PLANNING APPLICATION CONSULTATION RESPONSE

Application Number:	3/2024/0042
Proposal:	Approval of details reserved by conditions 6 (road adoption), 10 (surface water drainage scheme), 11 (surface water drainage operation and maintenance) , 12 (surface water drainage verification report), 13 (details of play equipment), 14 (protected species licence), 17 (electric vehicle charging points), 18 (external levels and finished floor levels), 21 (boundary treatments) and 22 (biodiversity enhancement) of planning permission 3/2023/0100.
Location:	Land west of Preston Road Longridge PR3 3BE

Lead Local Flood Authority Position

Drainage Proposals

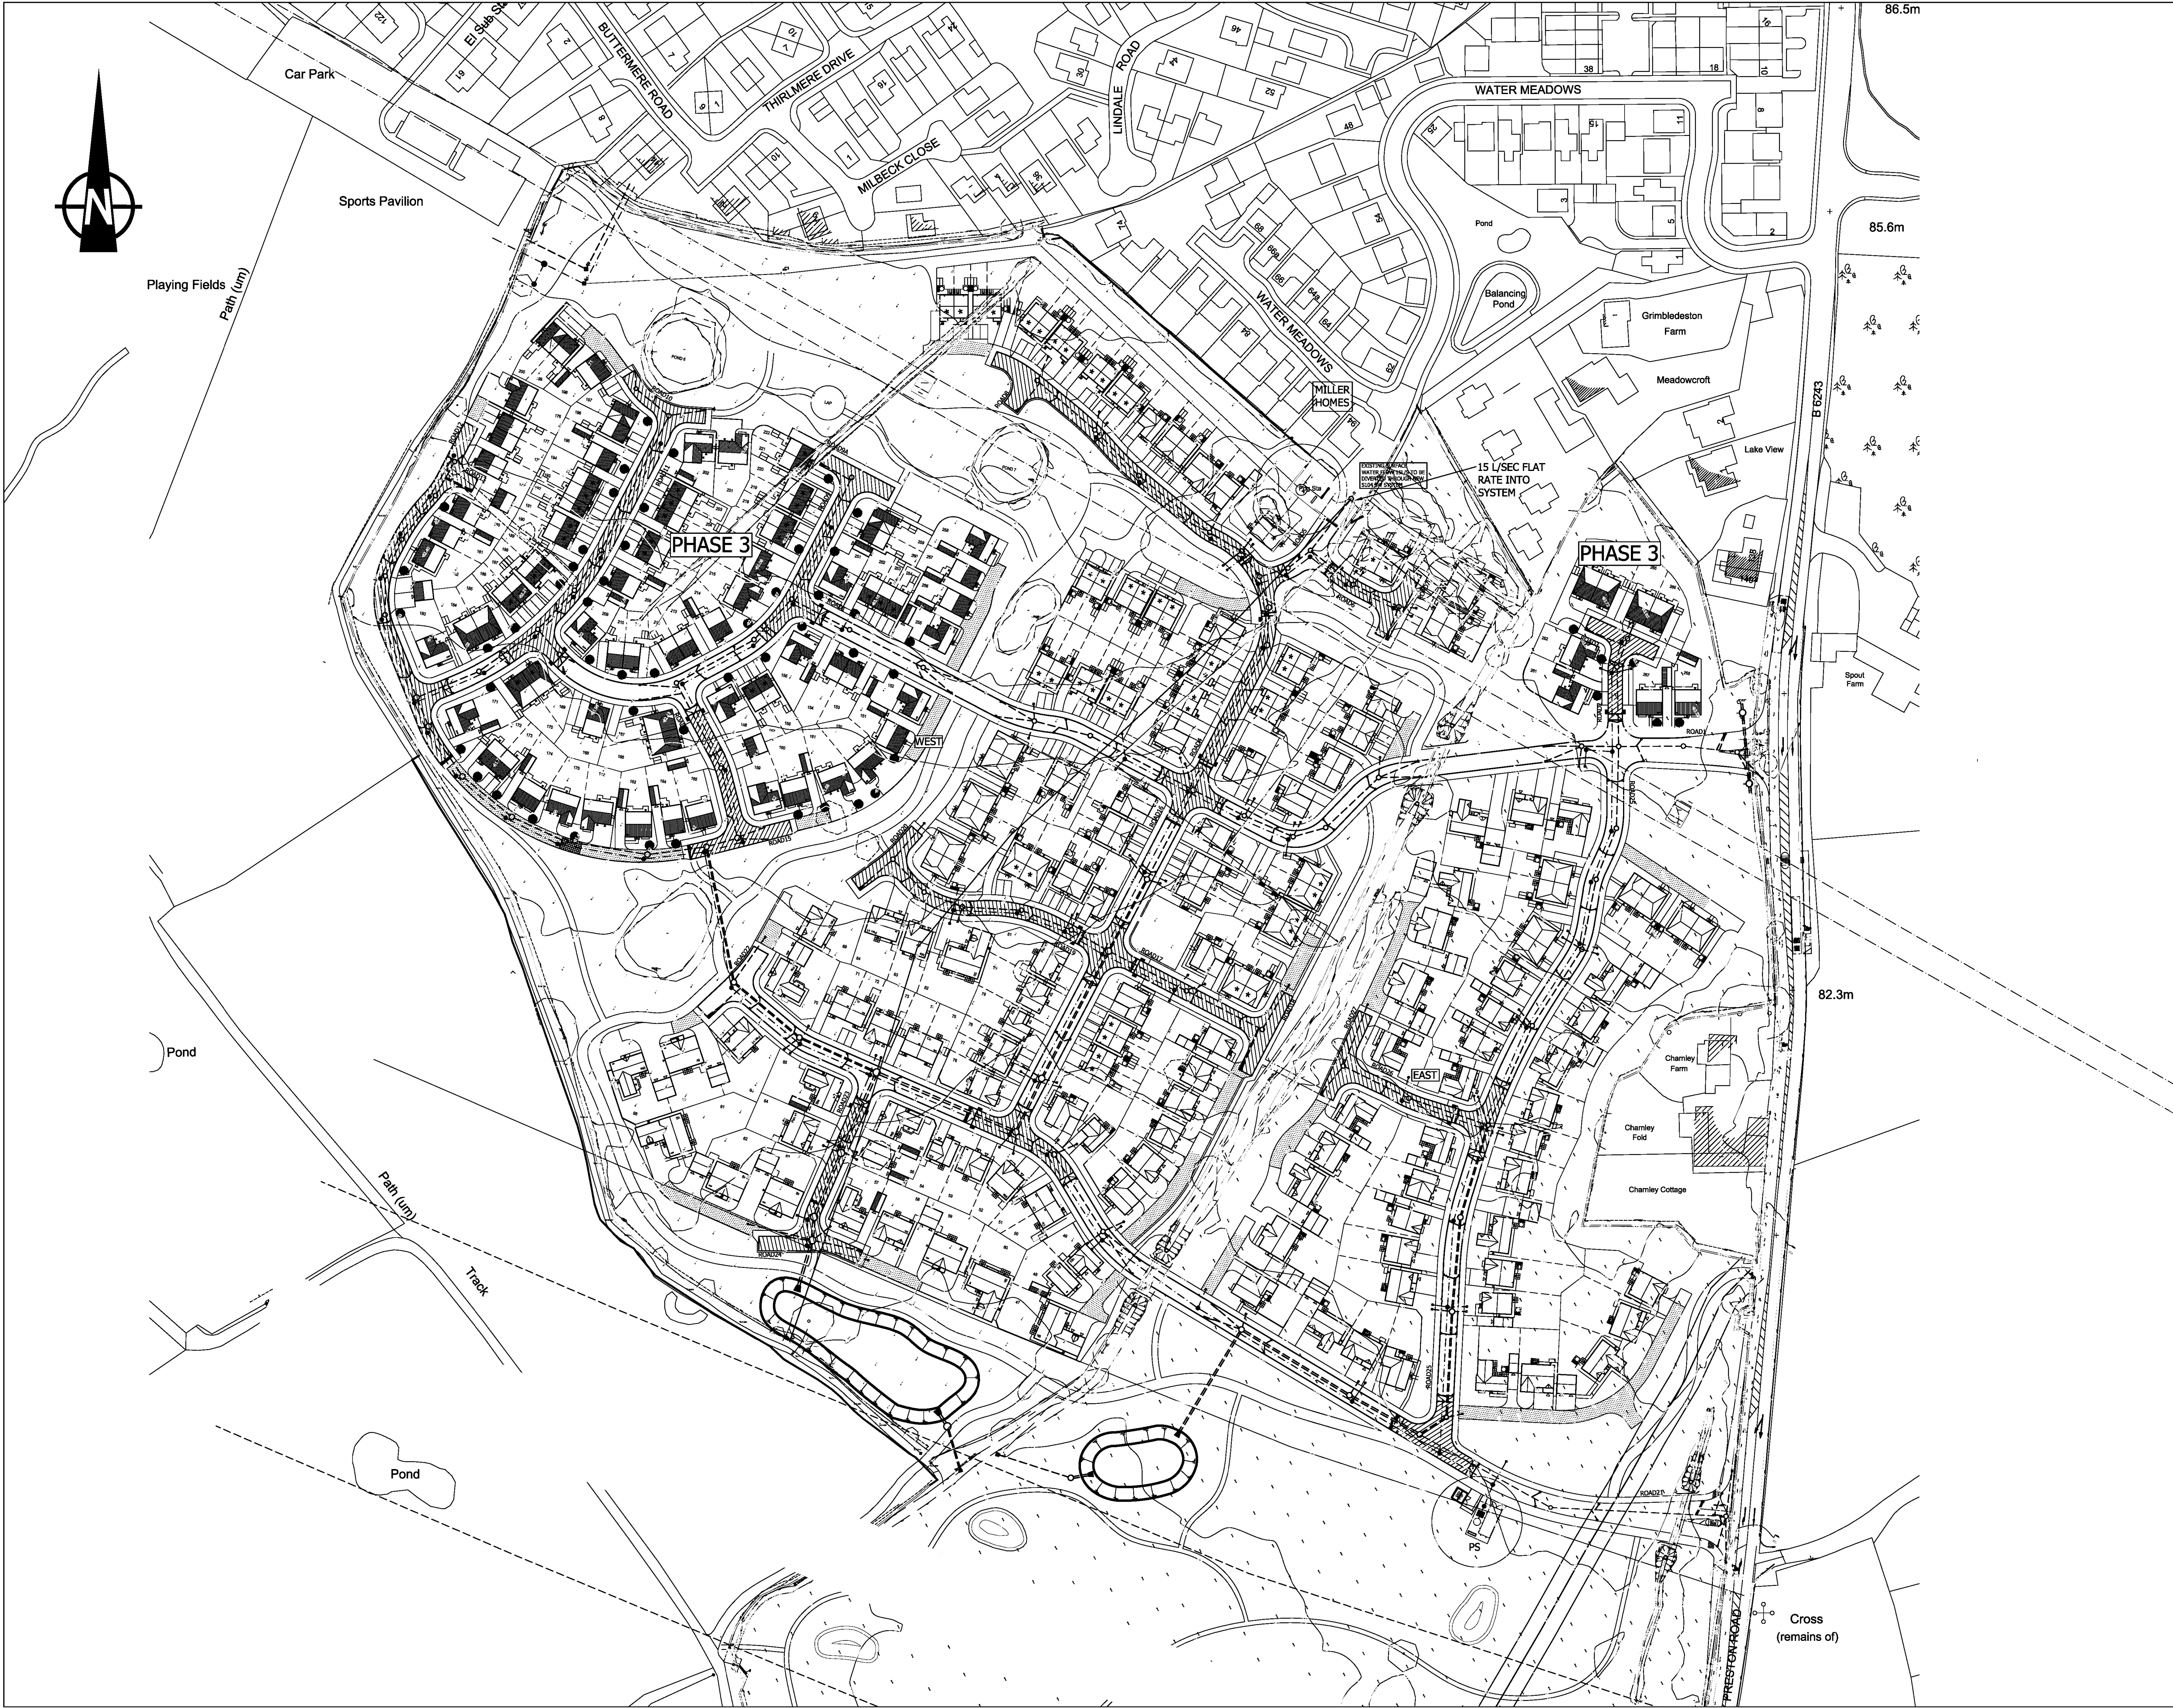
The Lead Local Flood Authority is currently **unable to recommend the discharge of condition 10** on planning decision 3/2023/0100 on the basis of:

- The applicant has failed to comply with condition 10 (section a) which requires the applicant to apply a 40% climate change allowance and urban creep allowance for

the 1in30 year and a 50% climate change allowance and urban creep allowance for the 1in100 year.

- The applicant has failed to provide evidence of an assessment of the existing on-site watercourse to be used, to confirm that these systems are in sufficient condition and have sufficient capacity to accept surface water runoff generated from the development.
